Little Crow Solar Park, Scunthorpe

APPLICANT'S RESPONSE TO S51 ADVICE

Applicant's Response to Section 51 Advice

# LITTLE CROW SOLAR PARK - LAND PLAN INCLUDING ORDER LIMITS

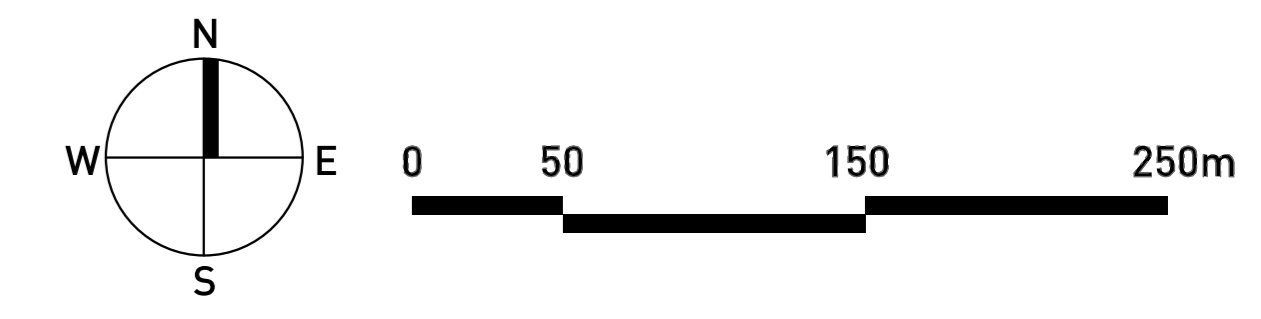
The Land Plans appended to the BoR also do not include the hatched area in the top righthand side of the boundary that is identified as being 'excluded from the Order limits' in the other plans included in the application.

Please provide clarification on the above or updated versions of the documents with corrections provided.

It is noted that the Land Plans appended to the BoR did not show the area of land which is excluded from the Order Limits. These have been updated and are now consistent with the Order Limits. Amended plans showing the excluded area are appended to the updated BoR enclosed with this submission (Document Reference 3.3A LC DCO).
